13 April 2018

CM/6/18/PL for Change of use to develop a concrete batching plant, with associated infrastructure, site offices & parking at Land at Northwood Farm Yapton Road Climping

Proposed South-East Elevation

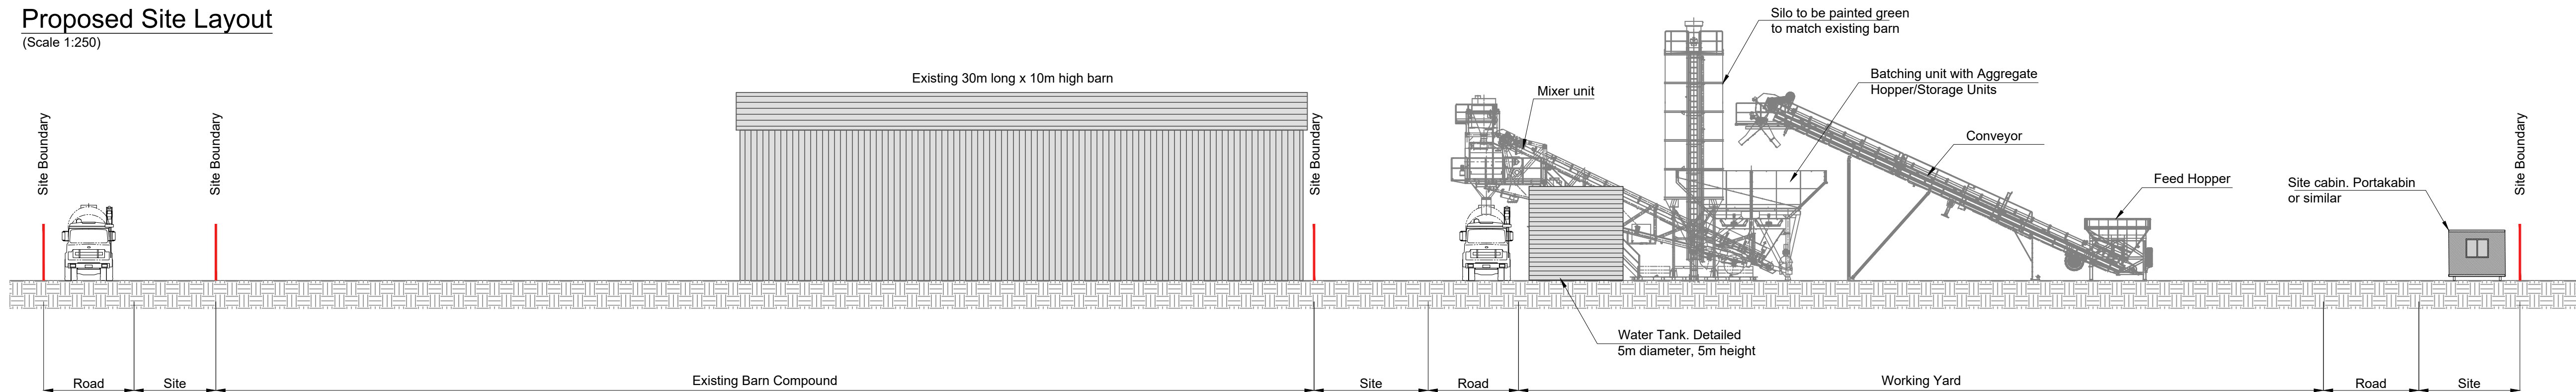
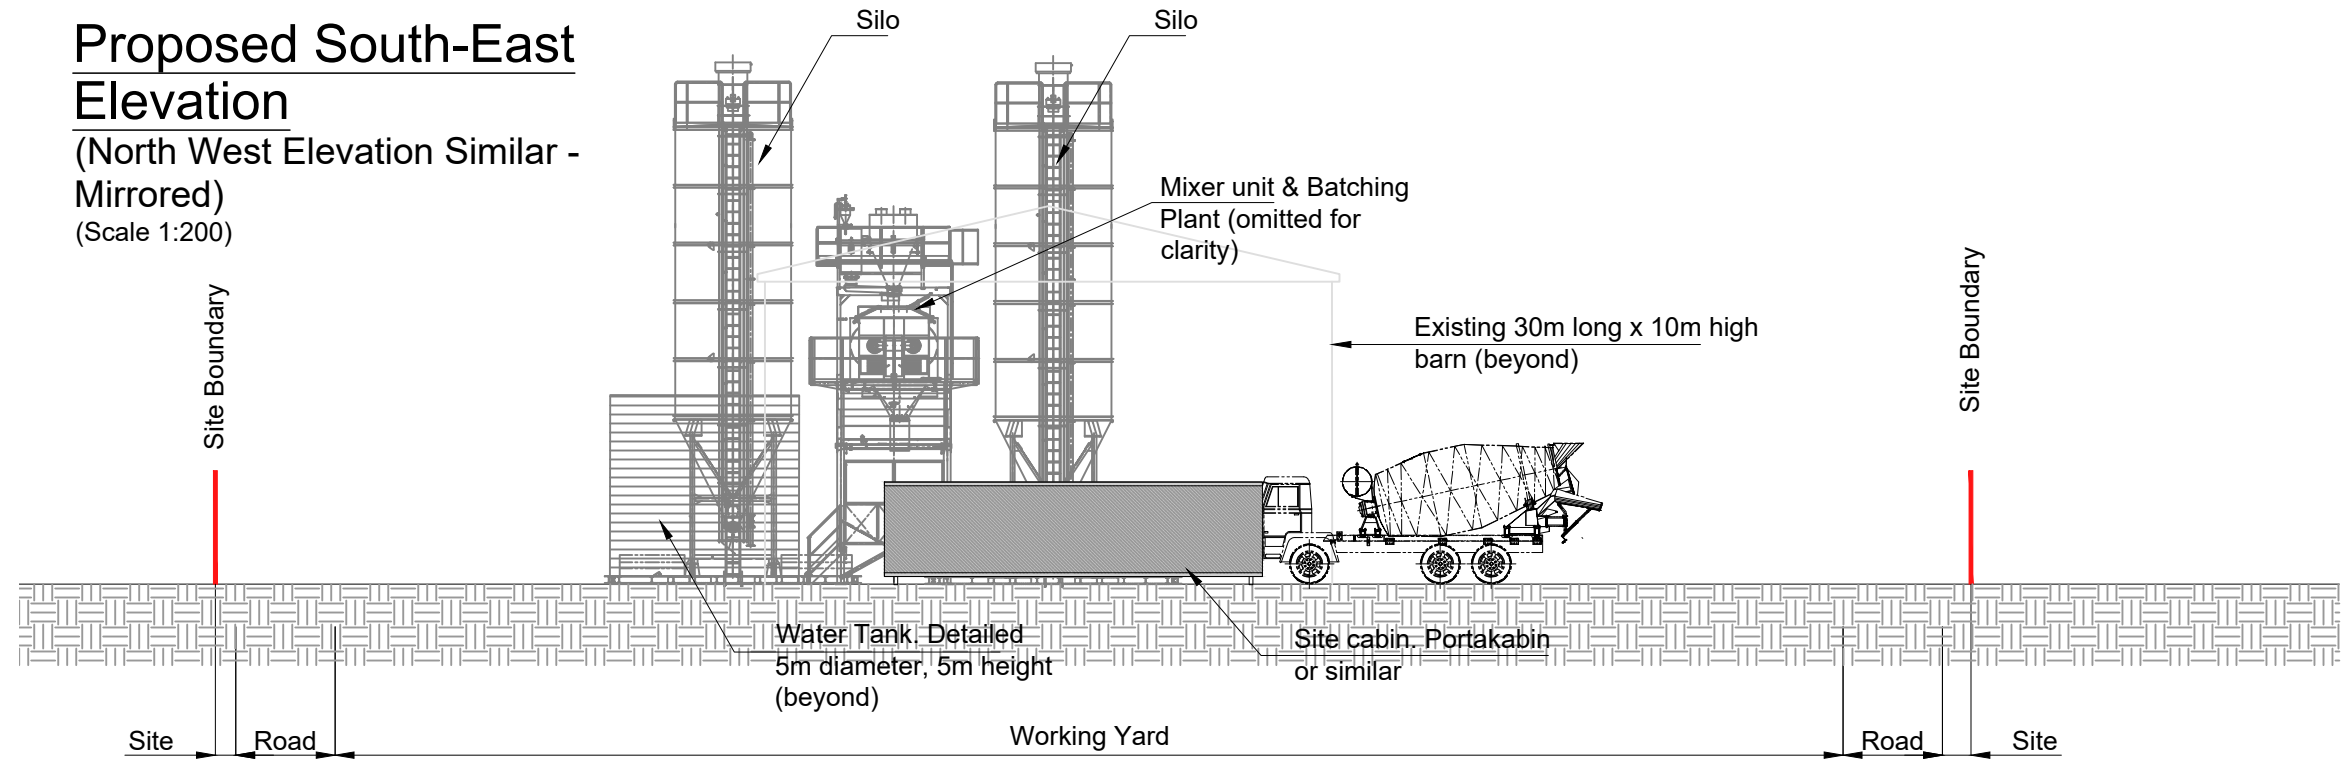
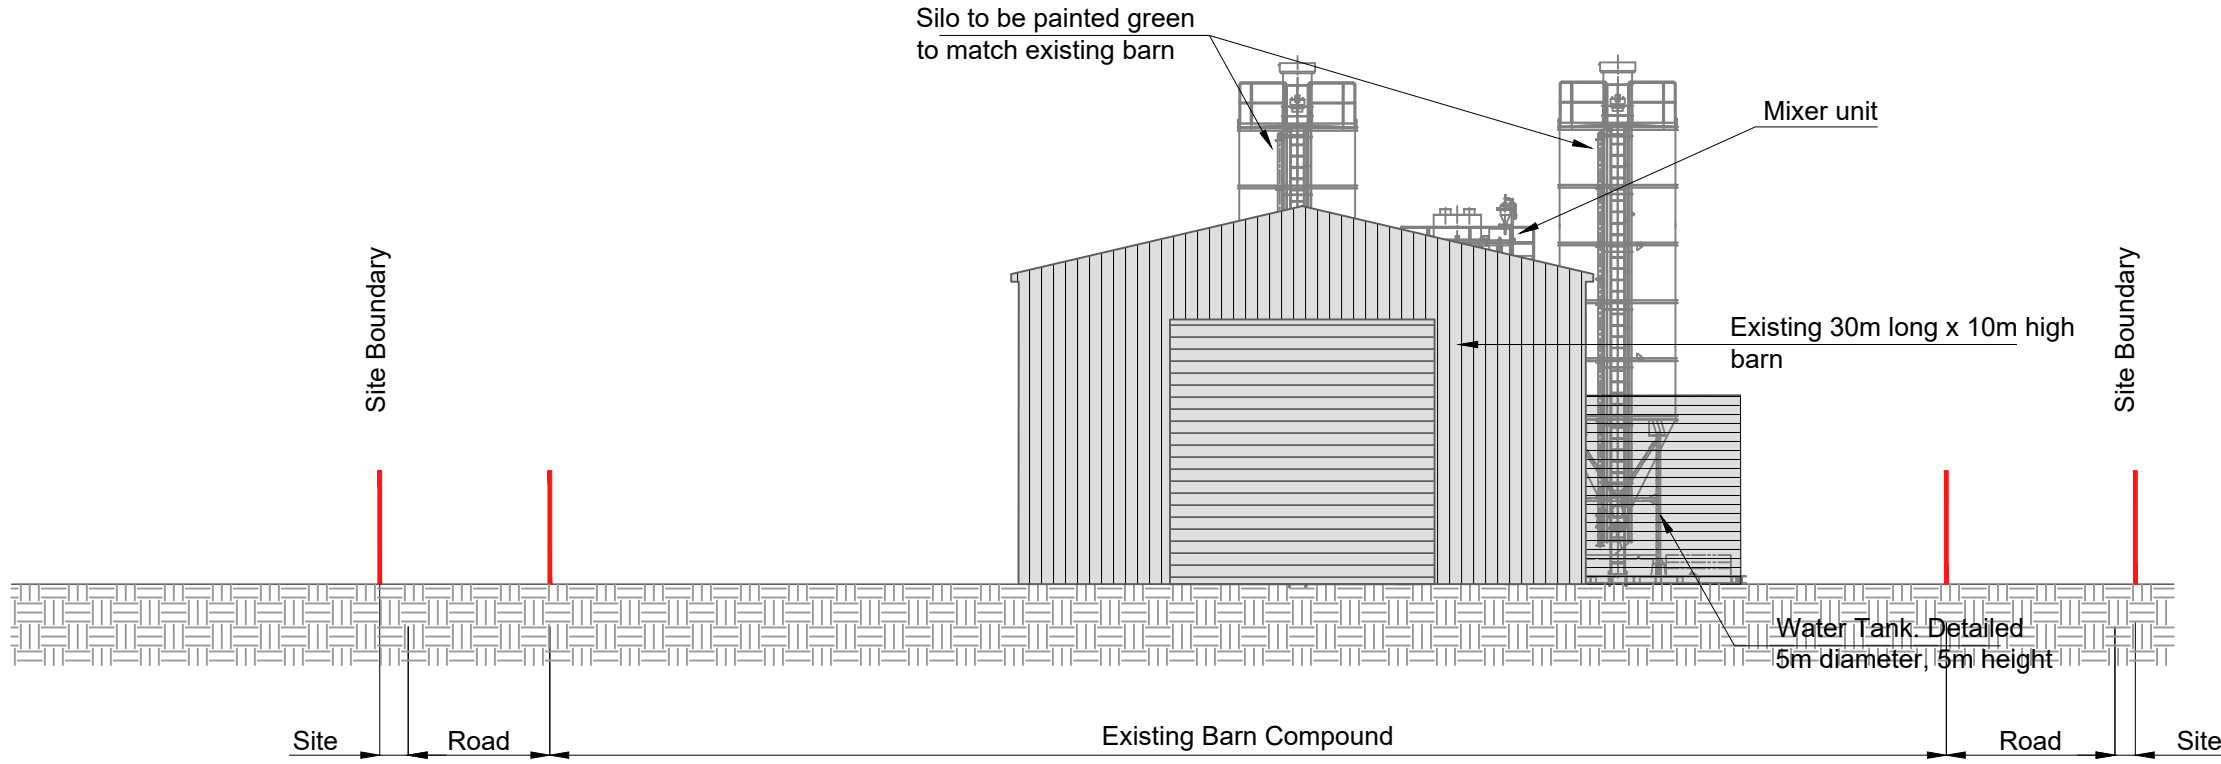
The total height of the silo structure appears to have been omitted from the plans, but they appear to be some 14m (45.93ft) high and because the height is beyond possible screening, will be another blot on the landscape.
